Cc:LHS Customer Service; planningSubject:app3/2018/0361 Victoria Mill, Sabden

The proposal has been the subject of pre application discussions with the highway authority and as a consequence the proposed layout has been subject to a number of amendments . For ease of reference I will refer to the note of the pre app meeting on the 14th December prepared by my colleague, Chris Nolan and submitted with the planning application documentation

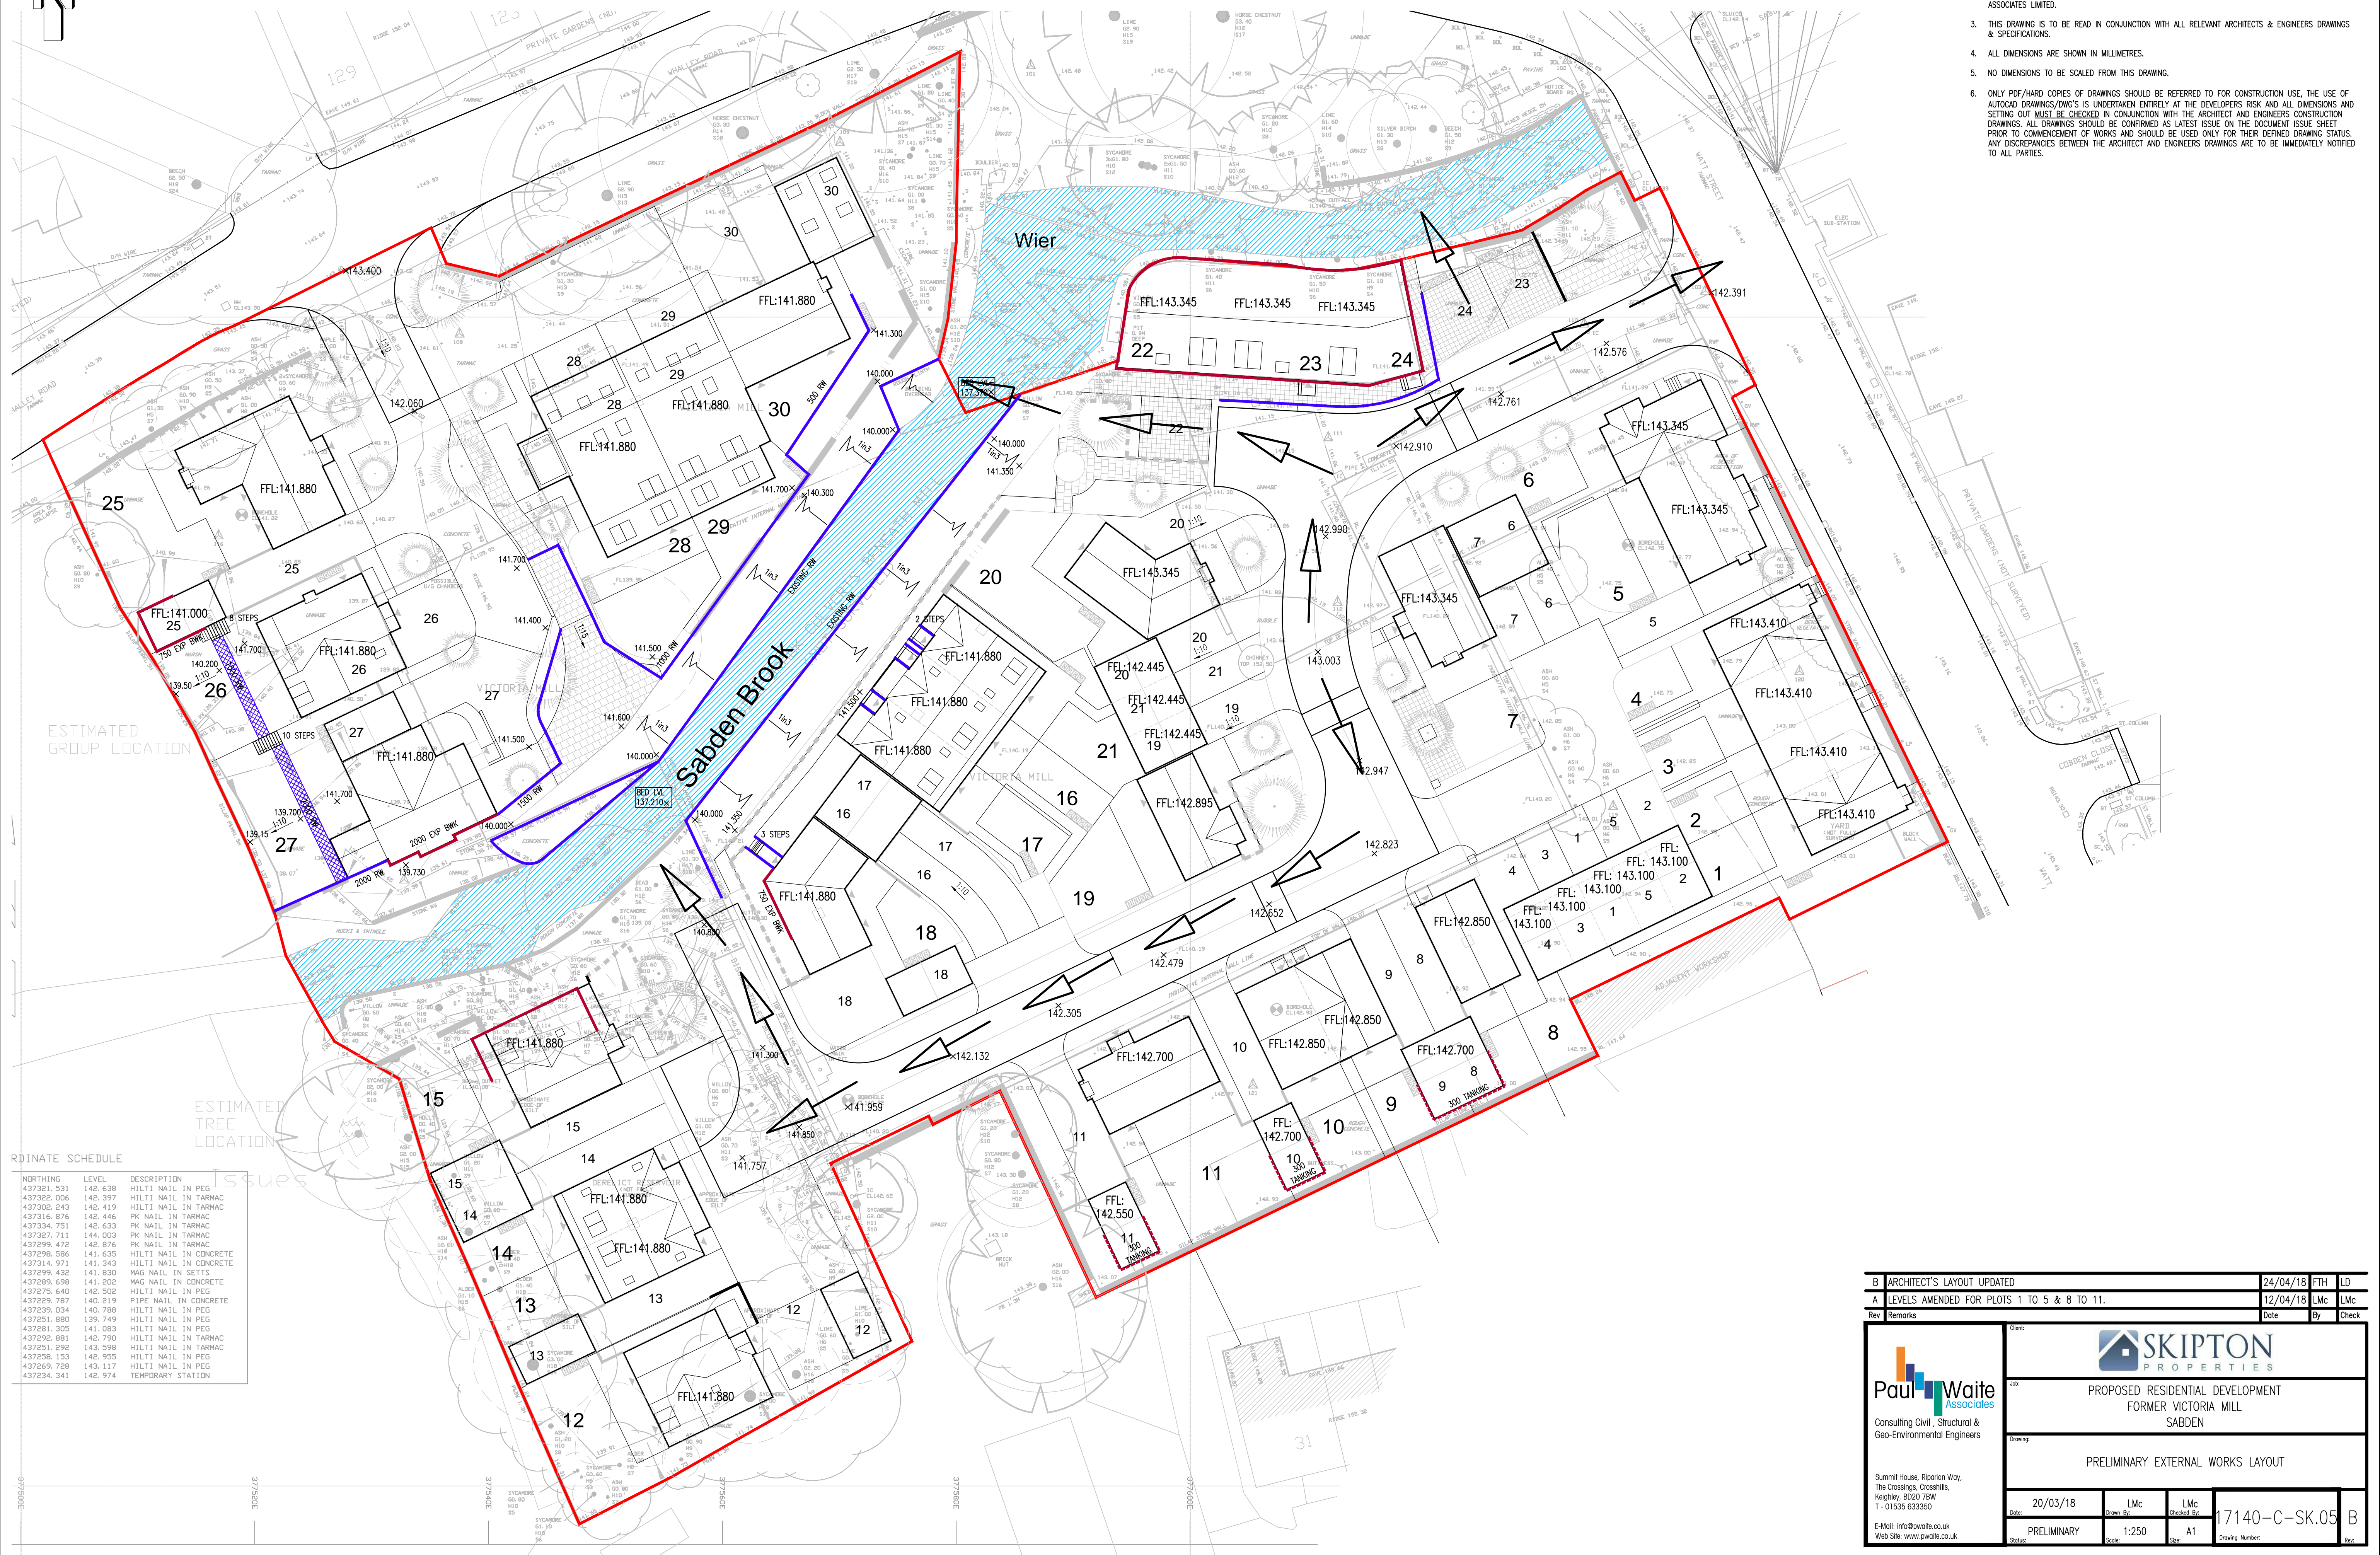
Width of adoptable estate road. The access into the estate roads off Watt Street is 5.5m and this would be acceptable. The LCC 's Residential Road Design Guide accepts a minimum width of 4.5m for estate roads serving less than 20 properties and on this basis the carriageway narrowing to 4.8m outside plot No. 9 would be acceptable.

The access off Whalley Road however remains at 4.8m and this should be increased to the specified minimum of 5.5m with 2m footways either side.

Footway widths. The proposals are acceptable, however bearing in mind the lack of footway provision to the east of the access on Whalley Road (due to land ownership issues) and footway should be provided for a minimum distance of 15m either side of the access measured from its centreline. As this is adopted highway there should be no land ownership issues. The provision will provide a safe refuge for pedestrian from the estate to cross to the footway on the opposite side of Whalley Road.

A landscaped area is shown on the line of the footway to the easterly elevation of plot 25. This should be removed and surfaced in appropriate materials commensurate with its pedestrian status.

Turning facilities. The turning facilities shown for the estate road on the southerly site are acceptable. A swept path is not provided for the smaller site off Whalley Road

The Square. (assumed to be smaller development off Whalley Road). The non-conventional layout would preclude the area from consideration for adoption although consideration would be given to adopt a short section of the access from Whalley Road but not to the extent shown on the site layout plan.

- 3 The proposed access from the site to Whalley Road shall be constructed to a width of 5.5m and this width shall be maintained for a minimum distance of 15m measured back from the nearside edge of the carriageway. Reason: To enable vehicles to enter and leave the premises in a safe manner without causing a hazard to other road users.
